From: Laura Gibbons
Sent: 15 August 2018 08:28
To: Michael Eastham
Cc: Planning.Responses
Subject: RE: *EXTERNAL: FW: LU/49/18/DOC - Kingley Gate (Courtwick)

Please see the email below and the attachments from Barratt Homes for the drainage of the sport pitches and associated buildings at Kingley Gate (LU/49/18/DOC – Condition 4).

"The information submitted regarding Condition 4 imposed on planning permission LU/282/17/RES: relating to the submission of a detailed level survey of the site including existing and resulting ground levels and the slab levels of the mixed use building and the changing facilities building is refused and the condition is not discharged as:

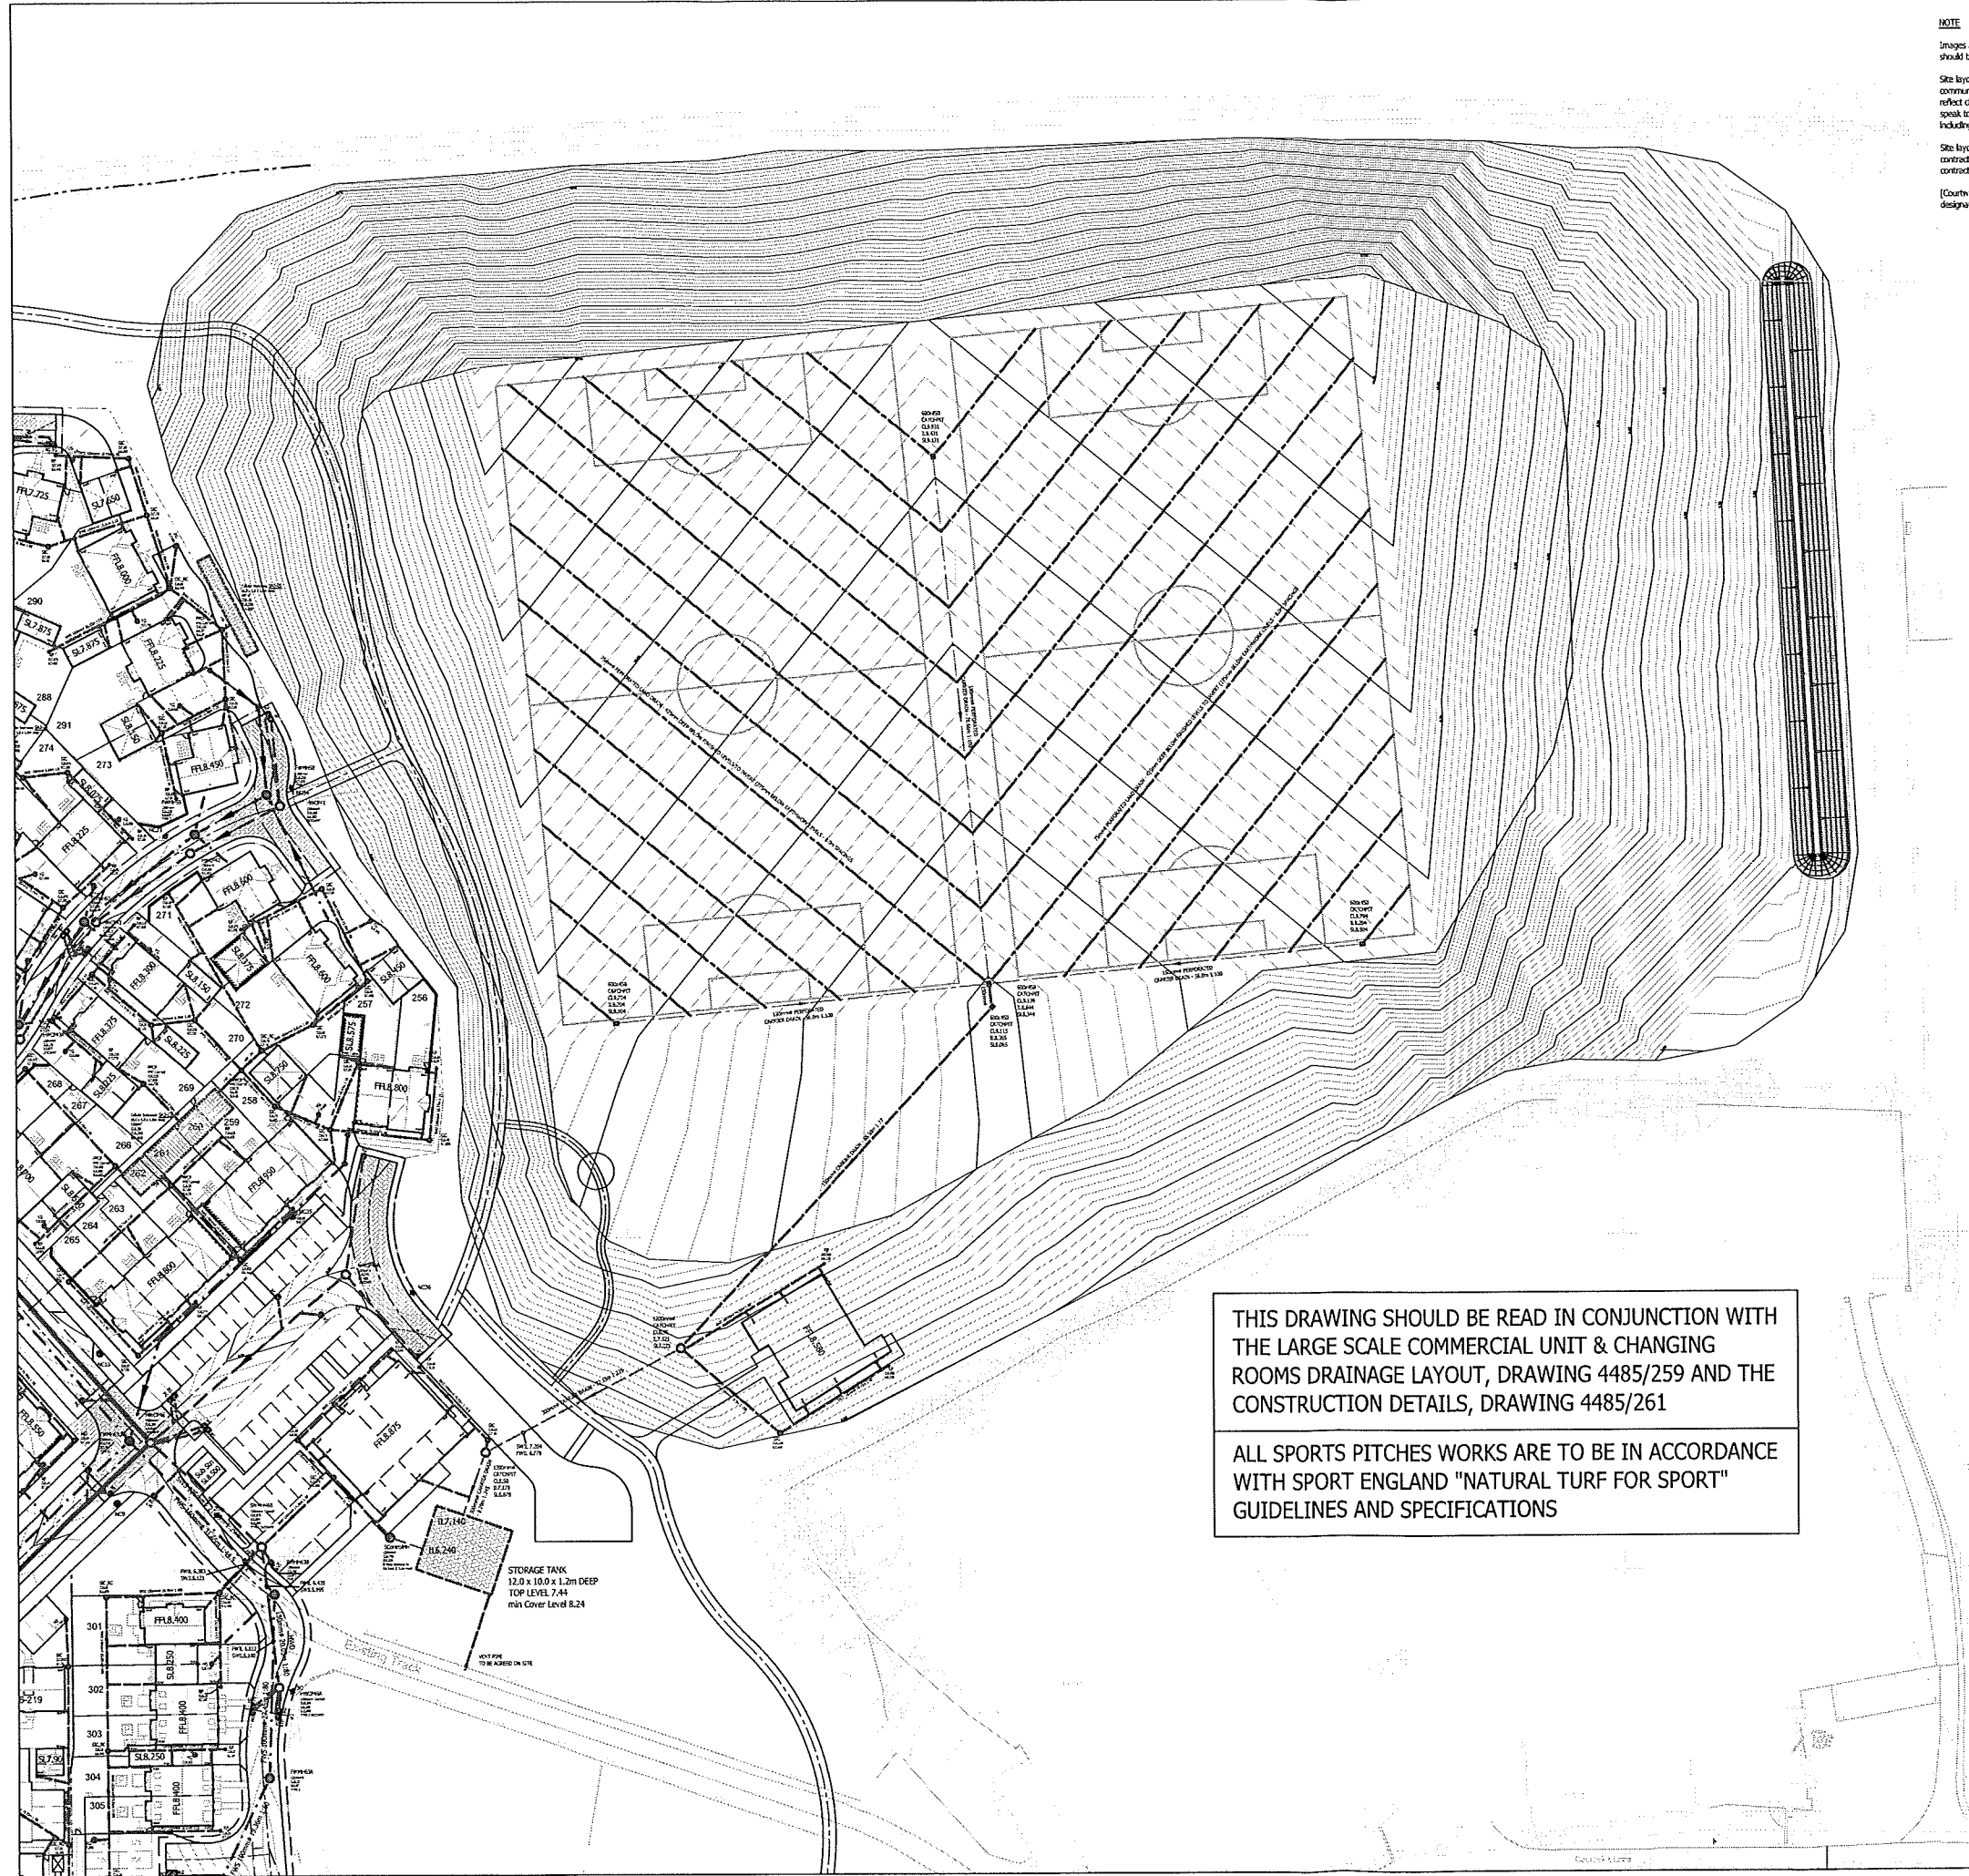
I have had an opportunity to look at the information provided. In order to fully check these please can cross sections of the proposed swales be provided. As well as a location plan with these shown.

Please can justification for an infiltration rate of 6.66×10^{-5} also be provided, i.e. test results.

- * The applicant has not supplied percolation testing data, or winter groundwater monitoring;
- * No calculations provided;

- * The applicant has failed to prove that there is capacity in the existing system for the sports drainage to discharge into the existing system at a controlled rate;
- * All soakaways are required to be located at least 5.0 metres from any building;
- * The applicant has failed to provide construction detail drawings:
- * The proposed soakaways surrounding the pitch would not have sufficient capacity. A swale system is required and a controlled discharge.
- * The proposed unmade pathways could compress with use and effectively create drainage channels as a result, directing water straight towards the houses to the west."
